WEST SUSSEX COUNTY COUNCIL CONSULTATION

TO:	Arun District Council FAO: Anita Gardner
FROM:	WSCC - Highways Authority
DATE:	12 June 2020
LOCATION:	Gladwyn, The Street, Littlehampton, BN16 1HT
SUBJECT:	EP/62/20/DOC Approval of details reserved by condition imposed under ref EP/179/18/PL relating to Condition Nos 3 - surface water drainage, 4 - visibility splays, 5 - car parking & turning arrangements, 6 - covered & secure cycle parking, 7 - materials & finishes, hard & soft landscaping and 10 - existing wall to south.
DATE OF SITE VISIT:	n/a
RECOMMENDATION:	Advice / More Information
S106 CONTRIBUTION TOTAL:	n/a /

This application seeks discharge of conditions 3 - surface water drainage, 4 - visibility splays, 5 - car parking & turning arrangements, 6 - covered & secure cycle parking, 7 - materials & finishes, hard & soft landscaping and 10 - existing wall to south.

Scales: 1:50 1:200
No: 2386/01/12

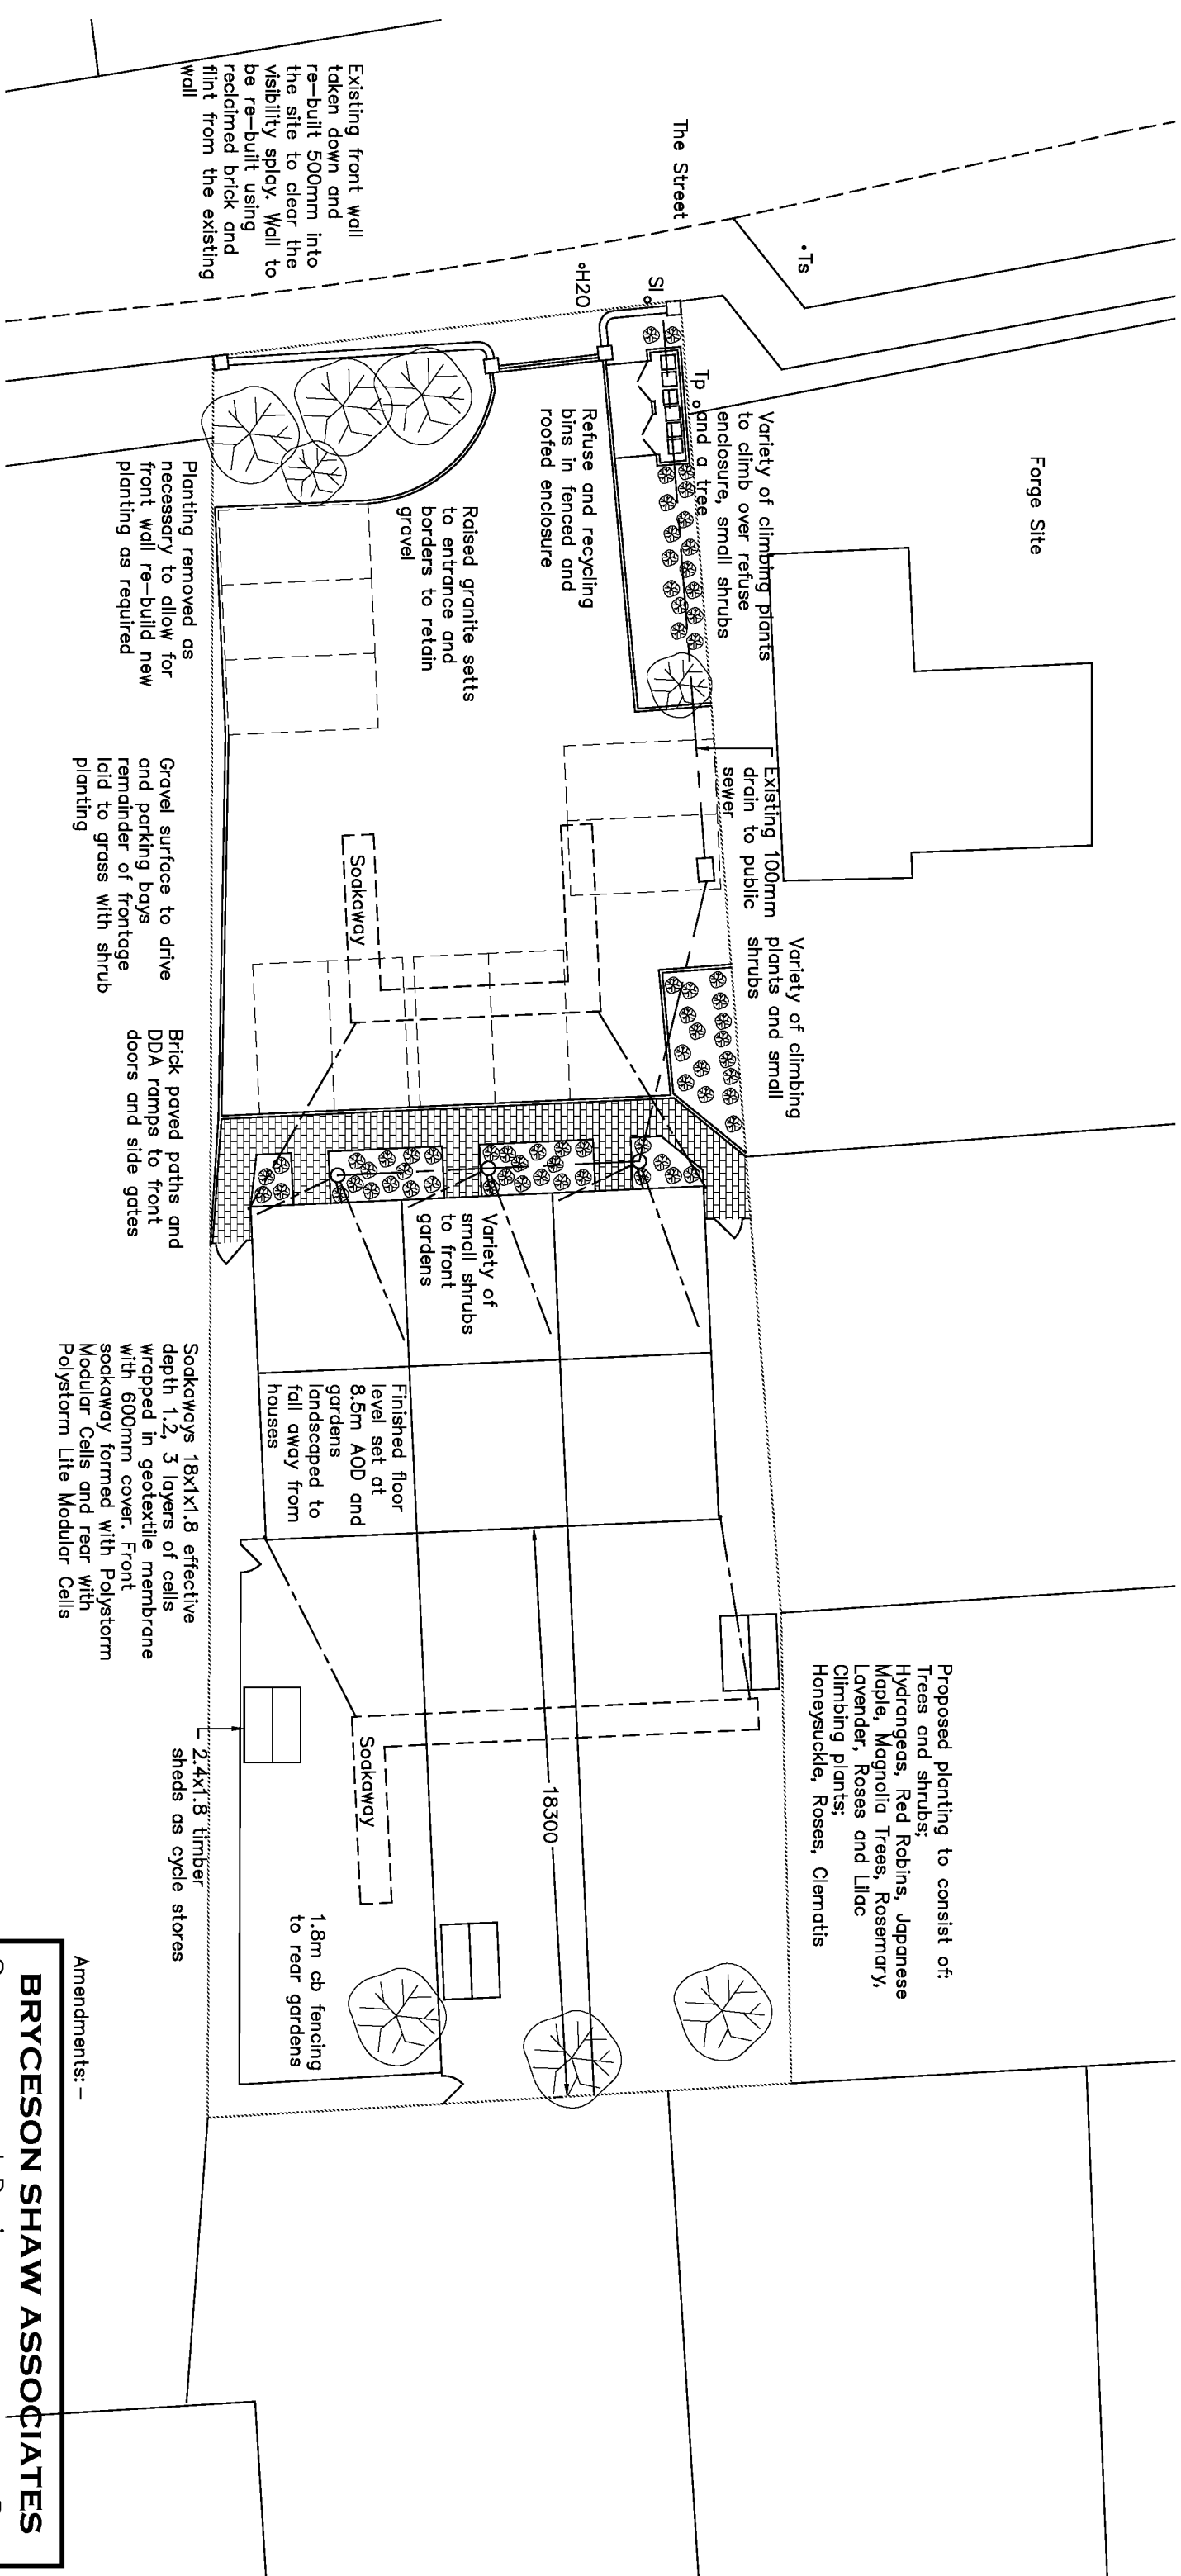
The provided plans indicate that 9 parking spaces will be provided on site. Each space meets minimum specifications of 2.4 x 4.8m in accordance with Manual for Streets. There appears to be sufficient space to the rear of eight of the parking spaces to enable vehicles to turn on site and exit in a forward gear. The LHA would request that the 9th parking space (the northern-most of the four spaces to the east) be re-sited further south to enable a vehicle to access and exit the

proposed parking space - this may involve re-siting the adjacent eastern parking spaces.

The proposed plans indicate that each dwelling will be provided with a garden shed for secure and covered cycle storage. Each shed will be 2.4 x 1.8m which is anticipated to provide sufficient cycle storage for the dwellings. The LHA is satisfied that this condition can be discharged.

From the details provided, the HA is satisfied that Condition 6 can be discharged. The LPA is advised that visibility splays should be provided in accordance with the approved plan prior to discharging Condition 4. With regard to Condition 5, the LHA would also request that the 9th parking space is re-sited further south to enable a vehicle to enter and exit sufficiently.
